From: Amanda Scholes on behalf of Planning.Responses
Sent: 14 July 2020 11:32
To: Planning Scanning
Subject: FW: D1833: Sunny Corner, Walberton WA/32/20/DOC D1833
Attachments: D1833-007F Construction Details Sheet 3 of 3.pdf; D1833-010B Pond Cross Sections.pdf; D1833-002E Engineering Layout - Below Ground Drainage.pdf; D1833 SW Design 1.2.pdf; D1833 Drainage Maintenance Schedule & Phasing Plan v3.pdf; D1833-001 Engineering Layout - Levels, Contours.pdf; D1833-300 Impermeable Areas Comparison.pdf

From: Laura Gibbons [REDACTED]
Sent: 14 July 2020 10:59
To: Planning.Responses <Planning.Responses@arun.gov.uk>
Cc: Andrew Wood <Andrew.Wood@arun.gov.uk>; Dan Lytton [REDACTED]
Subject: Fwd: D1833: Sunny Corner, Walberton WA/32/20/DOC D1833

The revised information is adequate to address our concerns and condition 8 can be discharged. Please ensure that the following plans are listed on any approval:

From: Laura Gibbons [REDACTED]
Sent: 23 June 2020 09:20
To: Dan Lytton [REDACTED]
Cc: Mark Akmenkalns [REDACTED] Jason Osborn [REDACTED]
Subject: Re: D1833: Sunny Corner, Walberton WA/32/20/DOC D1833

FLOW CONTROL CHAMBER

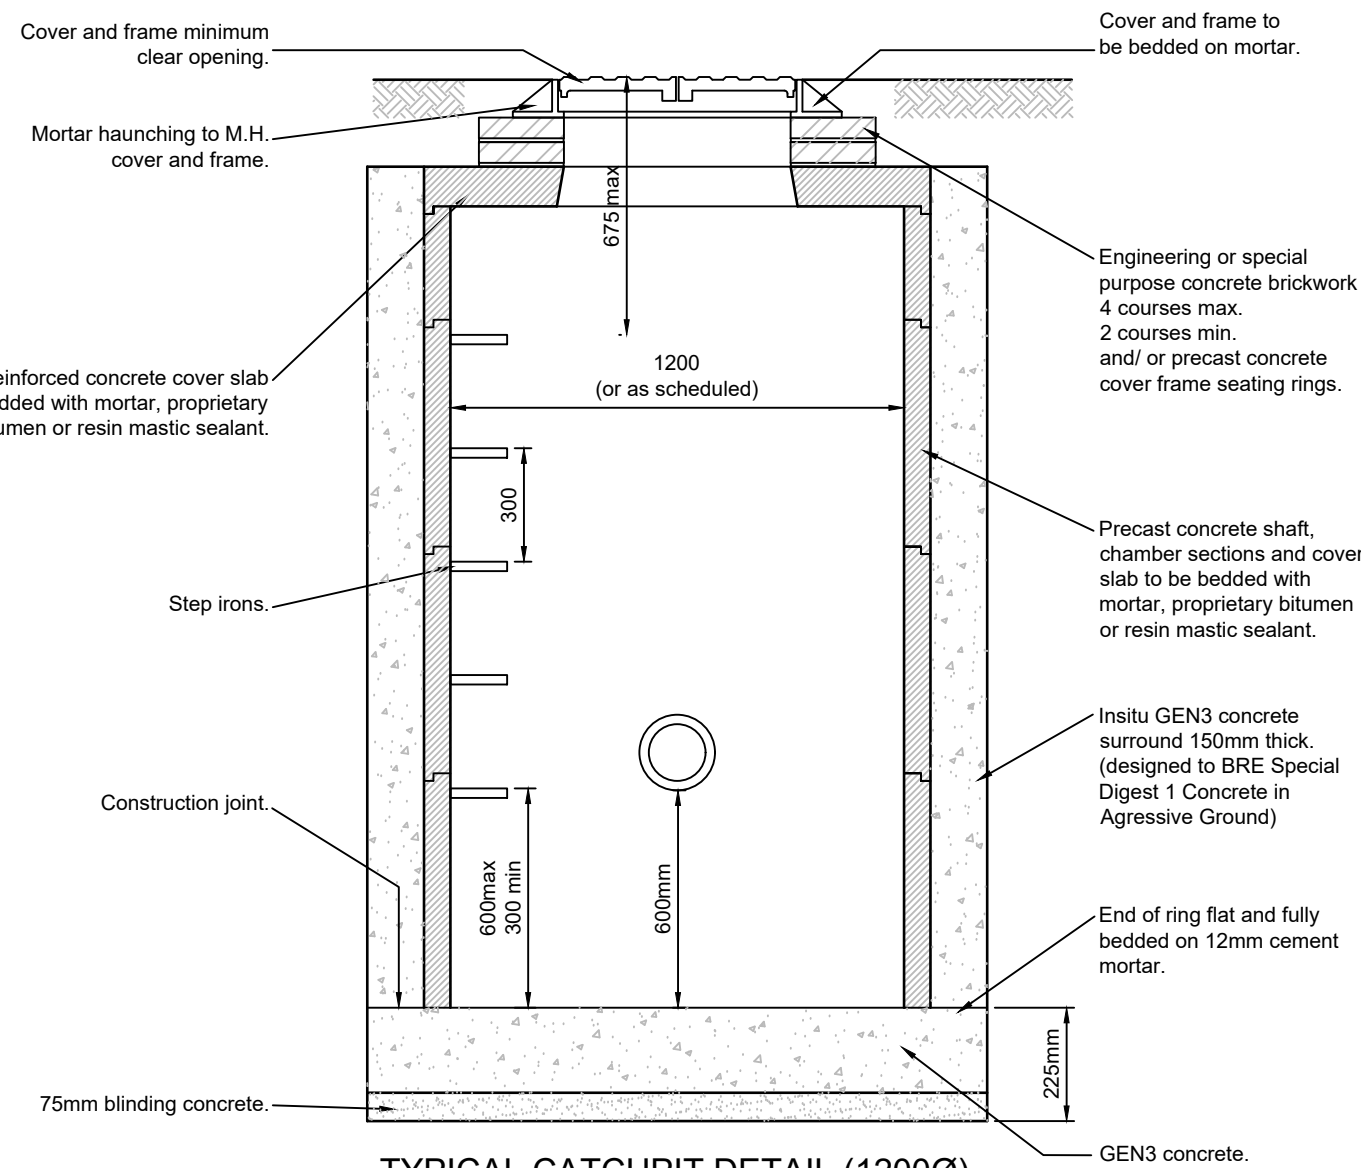
10. **Please confirm maximum recorded groundwater level at basin, if this is above liner level please supply flotation calculations.** Pond base raised from 16.10 to 16.15 (further reducing cut and improving freeboard between groundwater; already above recommendations from Andy T so floatation not an issue and you can see from the pond cross sections this sits out of the ground). *Please adjust construction detail drawing to not i.l. of 16.15*

- Site Boundary (9,359m<sup>2</sup> - 0.936Ha)
- Existing Impermeable Area (0m<sup>2</sup> - 0.000Ha)
- Proposed Impermeable Area (3,244m<sup>2</sup> - 0.324Ha)

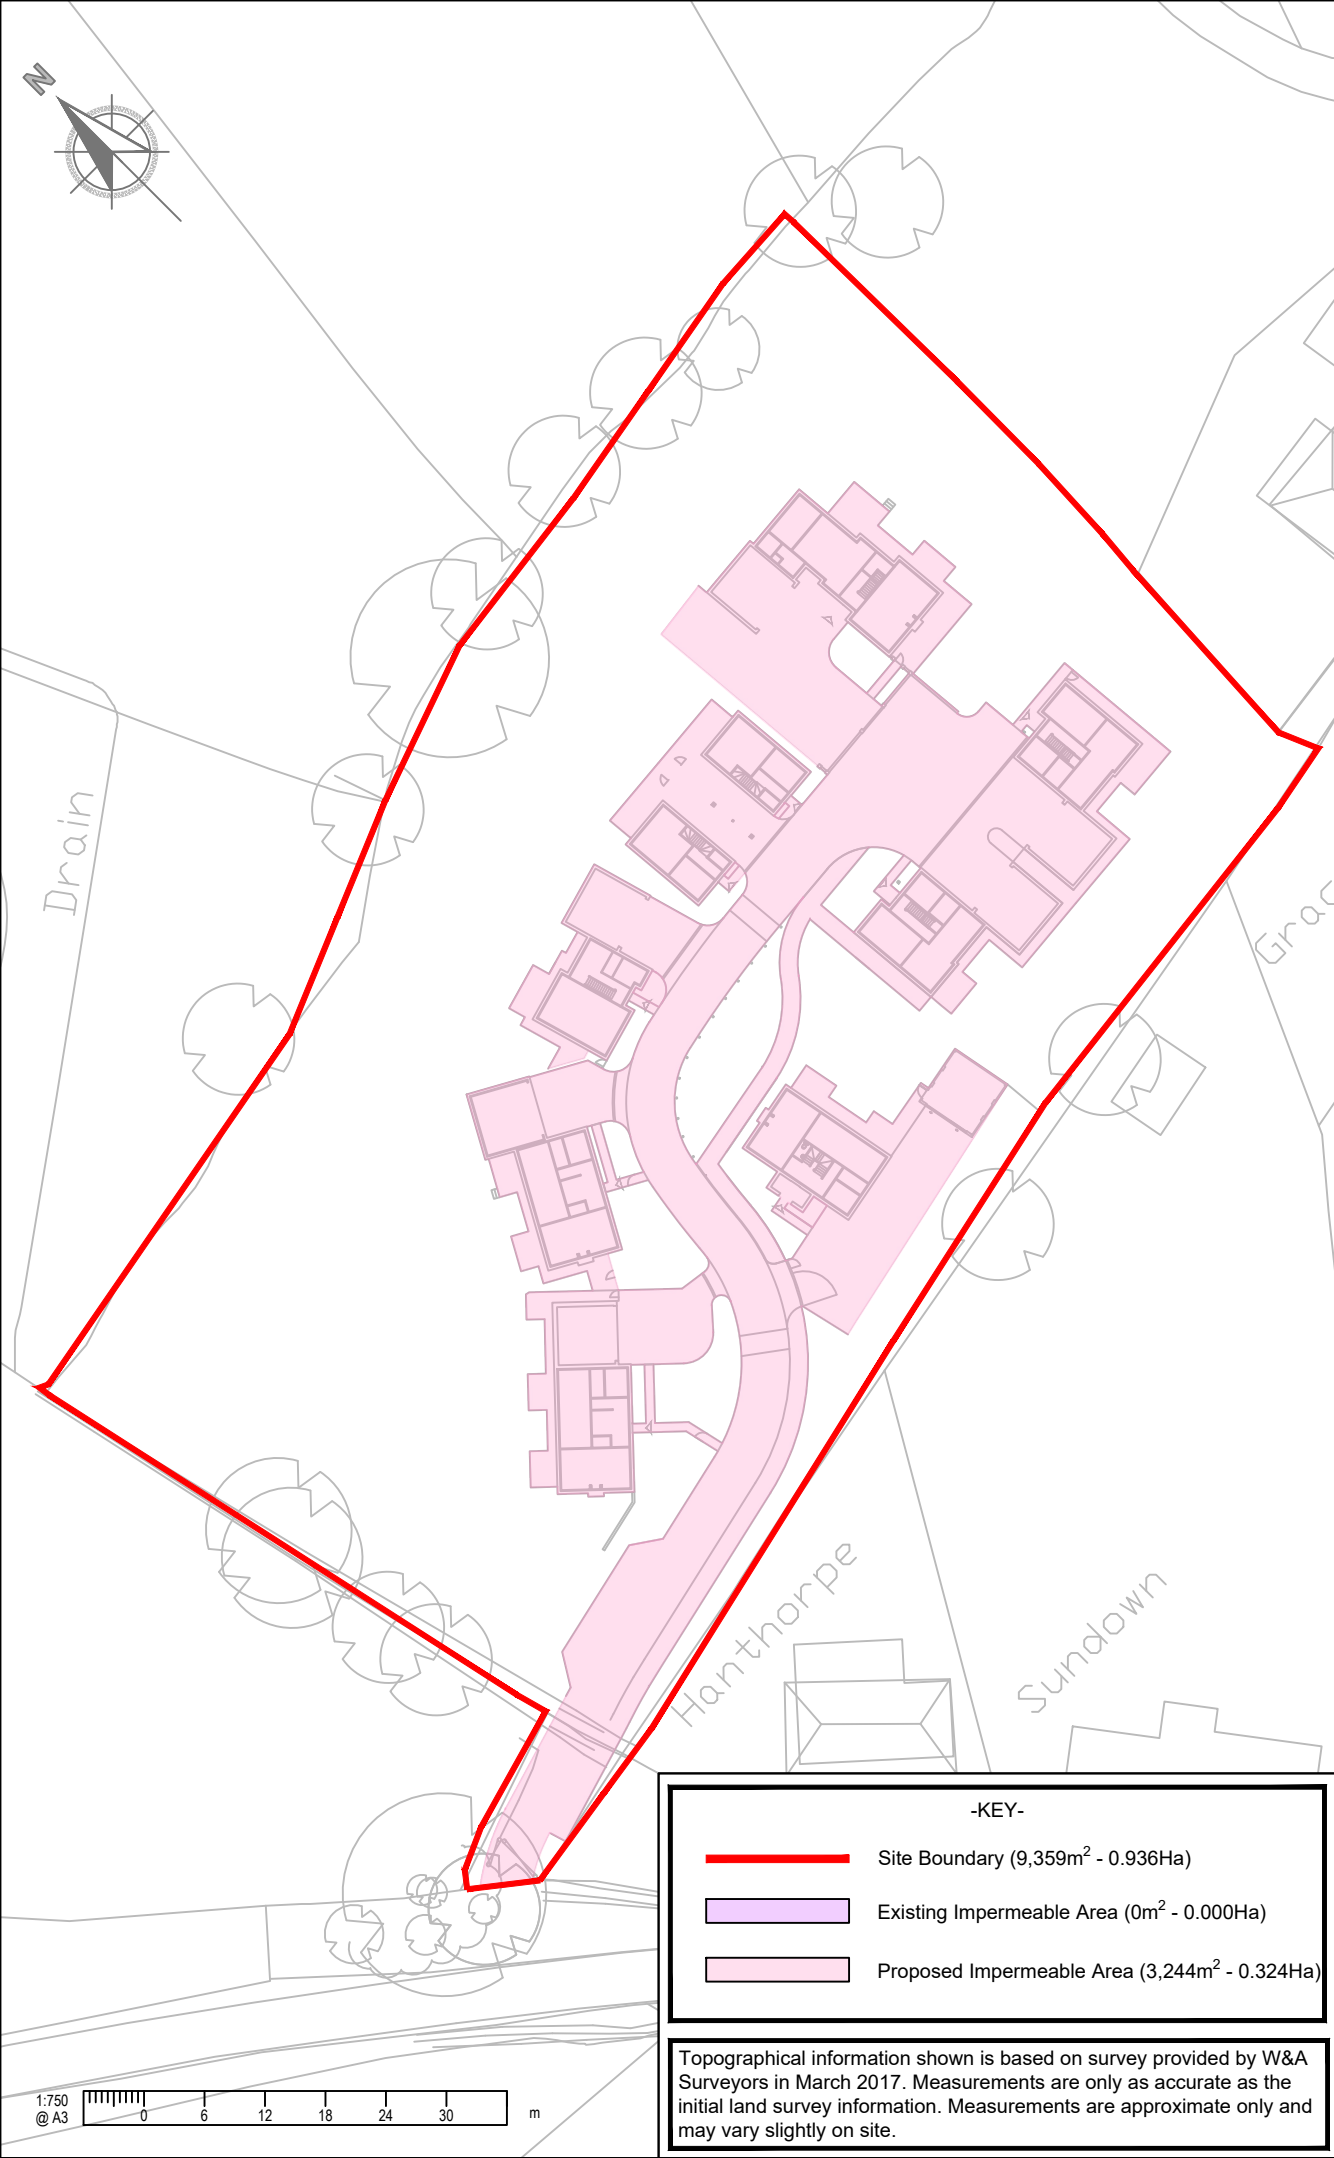
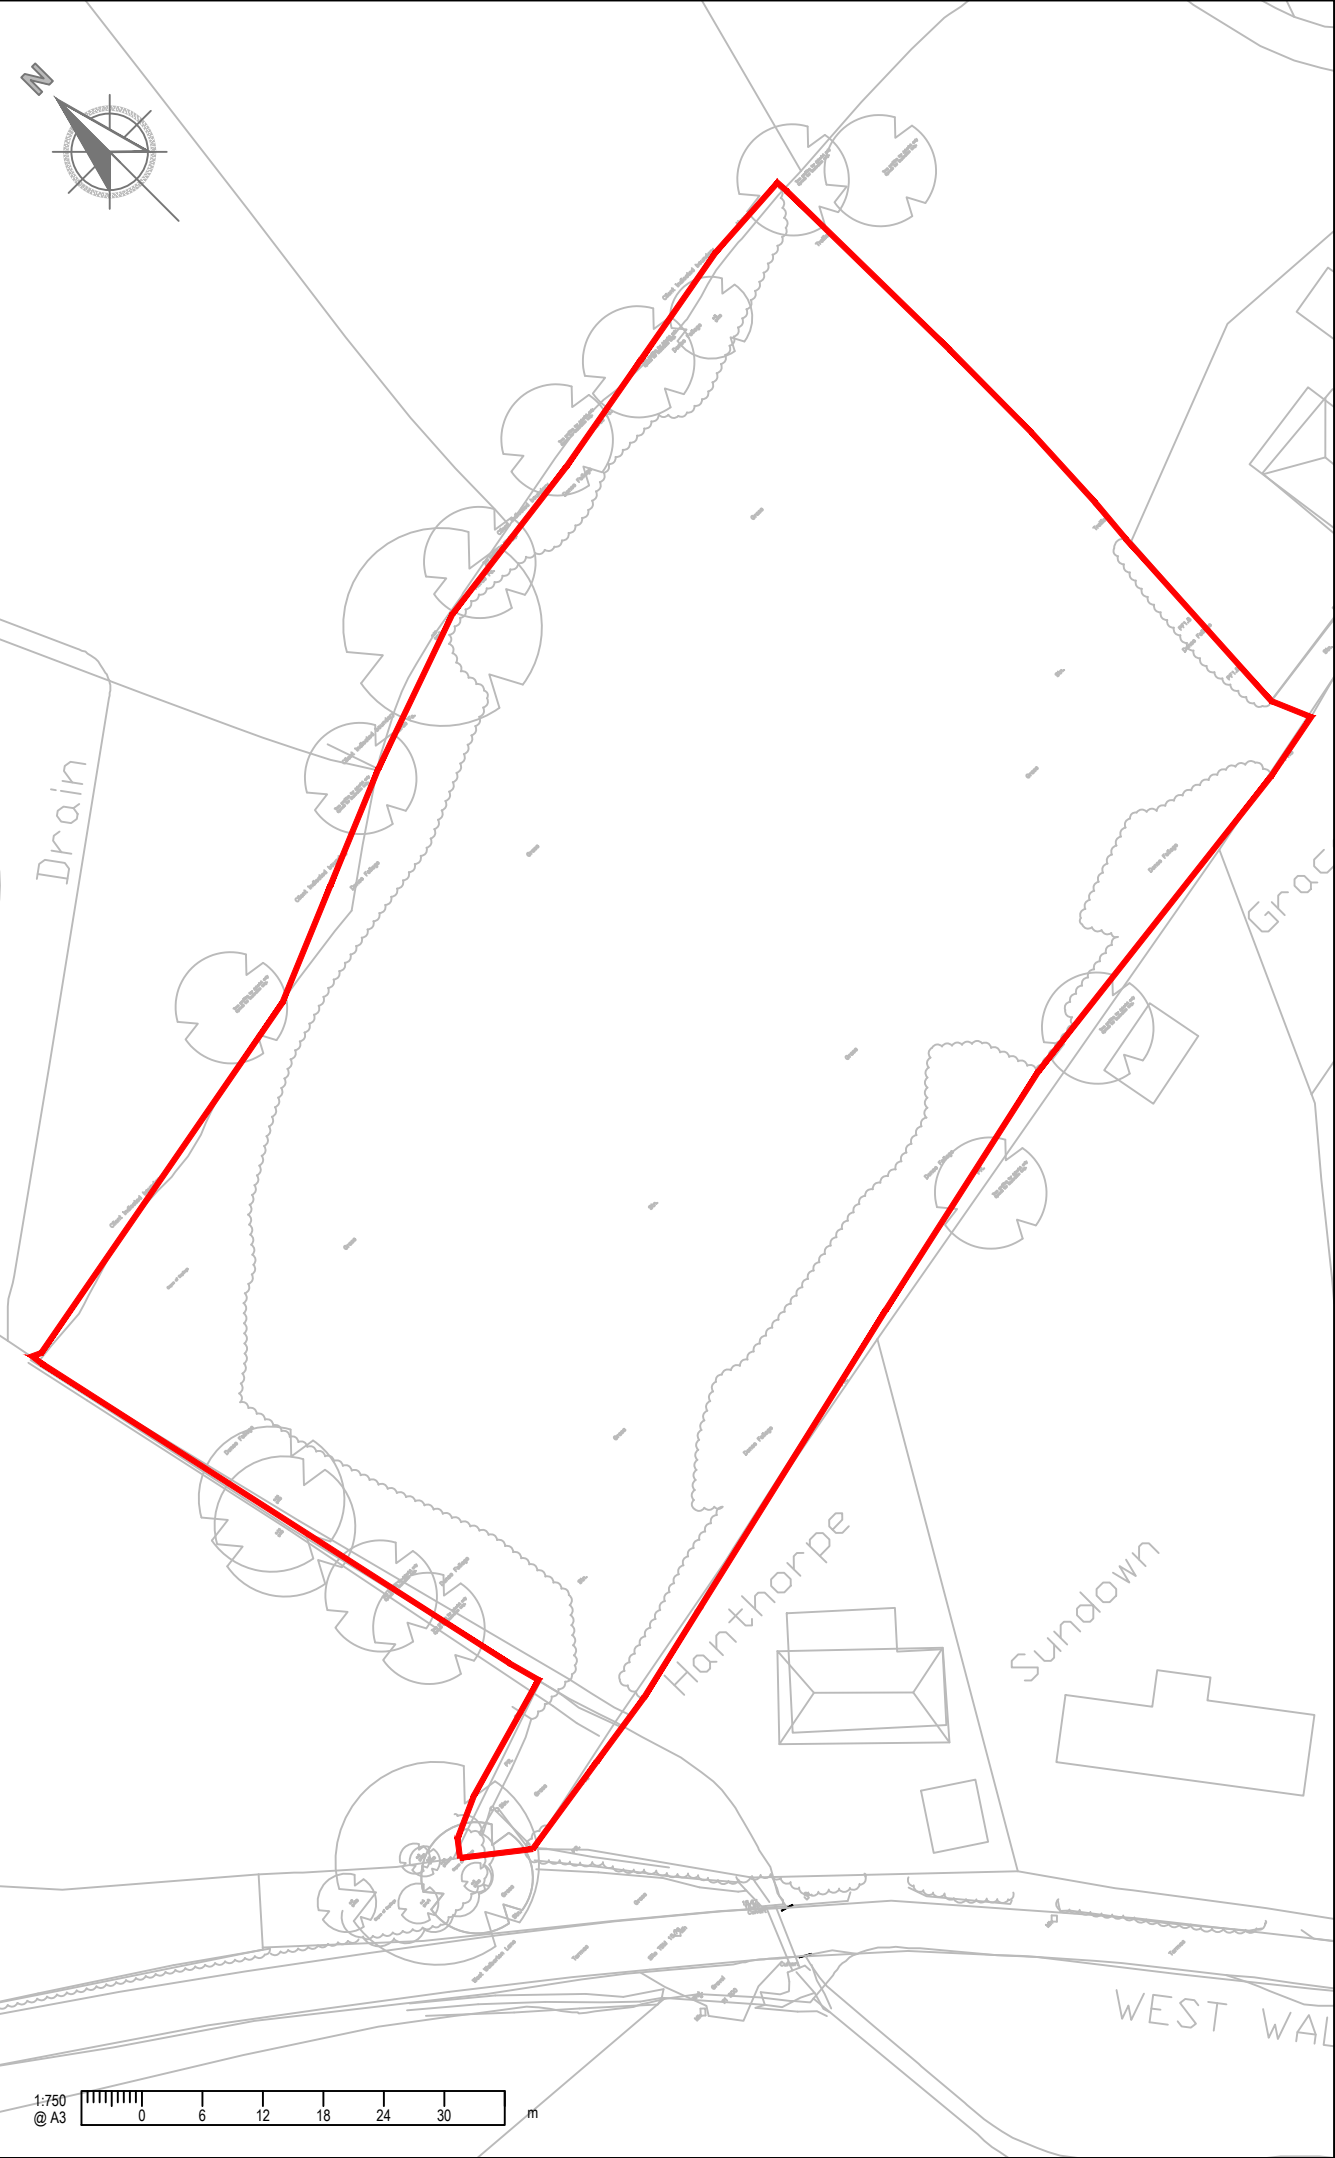
- 1. Please provide an impermeable areas plan.** Please refer to permeable areas drawing D1833-300, attached for reference. Impermeable area plan indicates 0.341Ha. Main drained area 0.231Ha, road catchment 0.048Ha. Total of 0.279Ha modelled. Please detail where this discrepancy is from or make amendments to calculations to ensure impermeable area modelled is the area designed..
- 2. There are discrepancies between the calculations received and the drainage layout.**

1. Impermeable areas have been updated in line with drawing 300, however as with any site runoff from some impermeable areas such as rear patios or footpaths will never drain to the pond (these areas will drain to landscaped areas), therefore impermeable areas included within the model are an absolute maximum.
